Our Ref: A/9/18/PL
Your Ref:

Town & Country Planning Act 1990 (as amended)
Town and Country Planning (Development Management Procedure) (England) Order 2015
Application for Planning Permission

Development Change of use of land to a Gypsy & Traveller Caravan Site consisting of 1 No. mobile home, 1 No. touring caravan & 1 No. amenity building. This application is a Departure from the Development Plan.

Location The Caravan Site New Road A259 Rustington

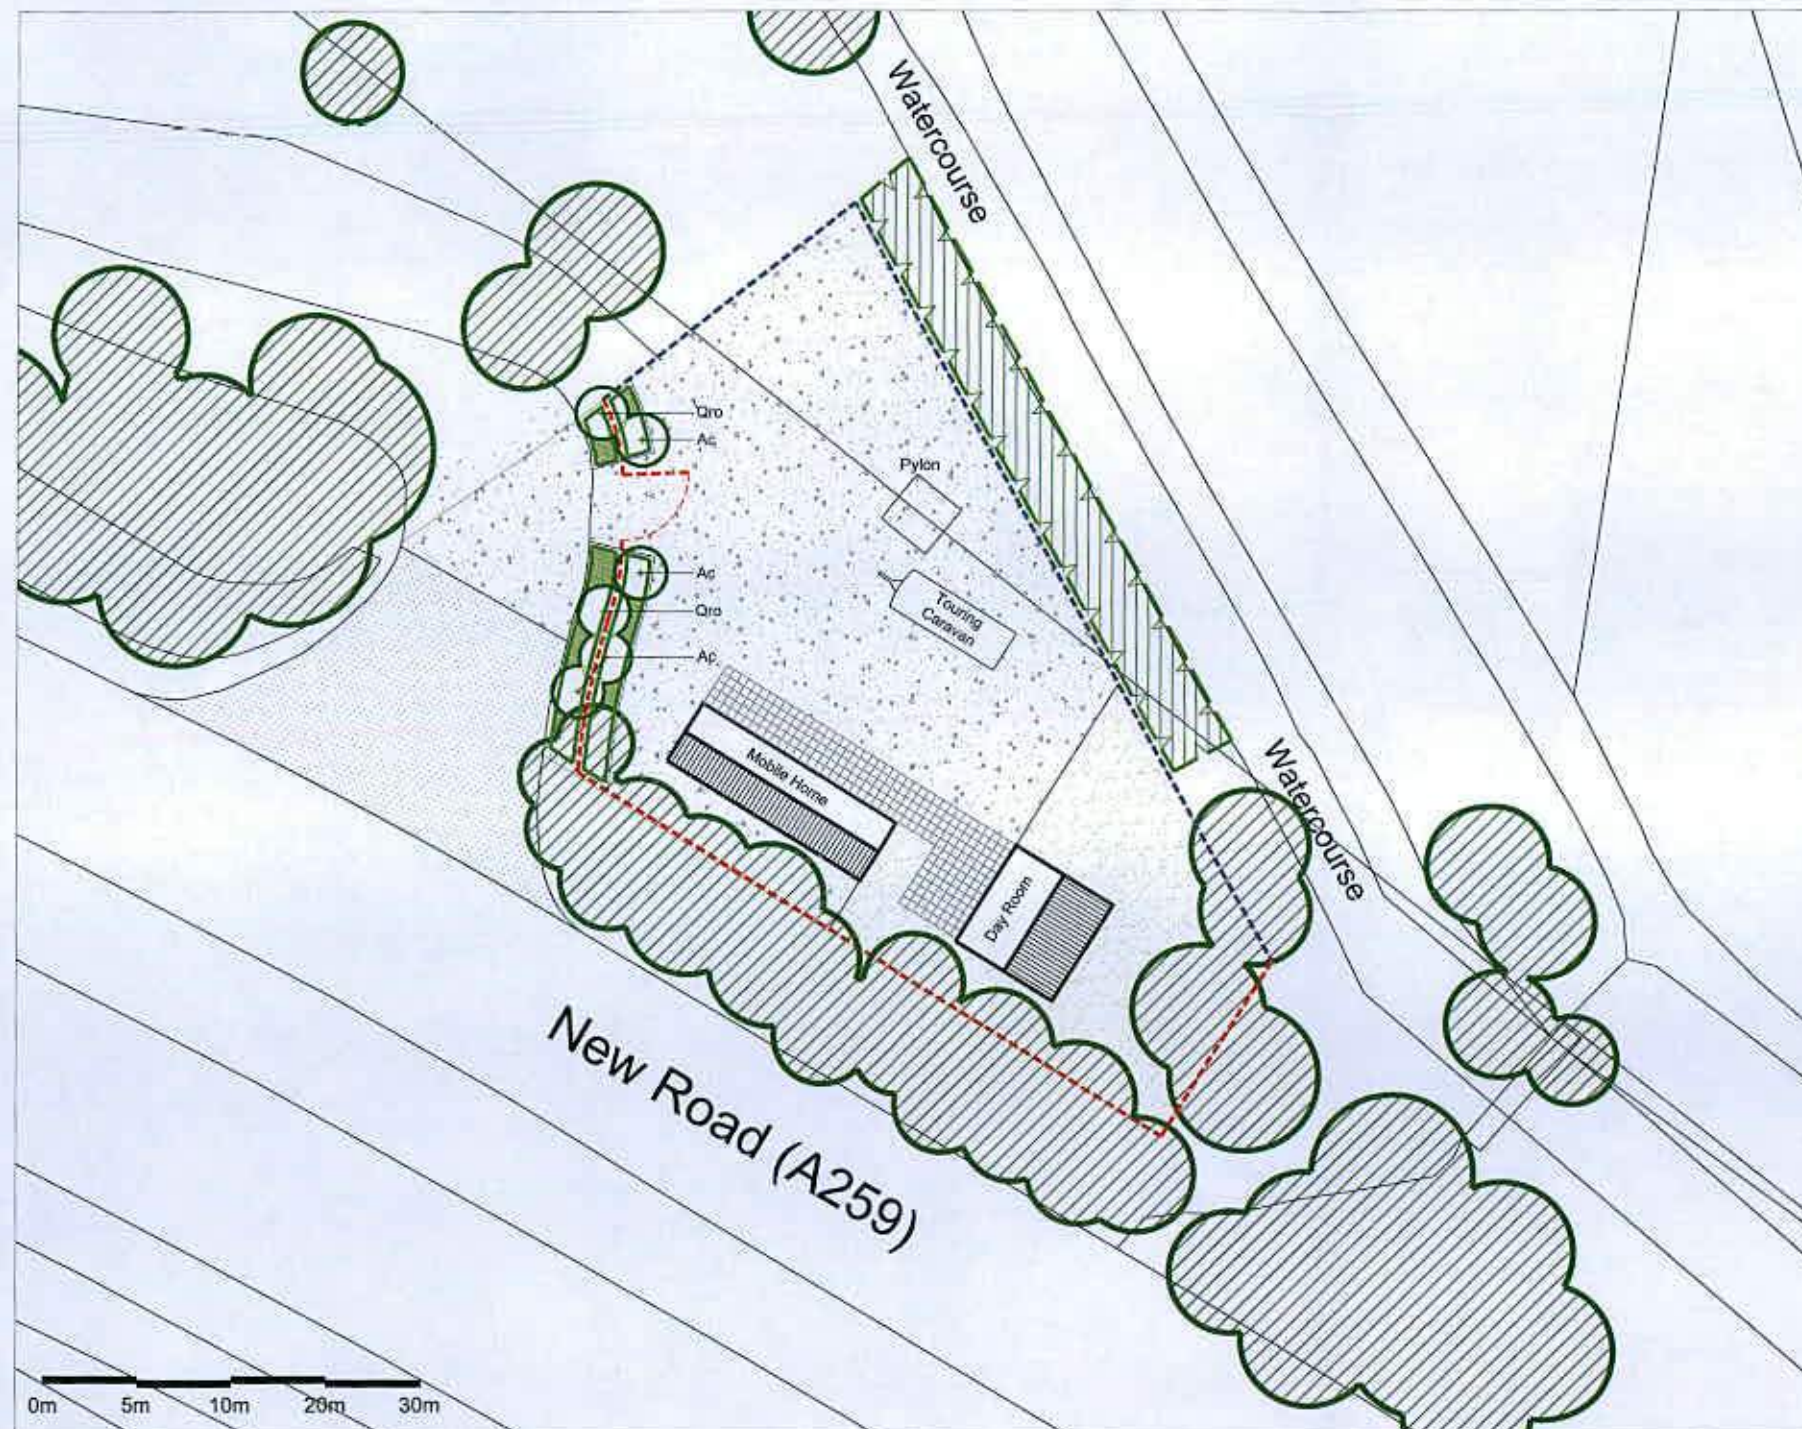
On the site layout/landscape scheme, please show the position of rubbish/recycling bins and parking bays.
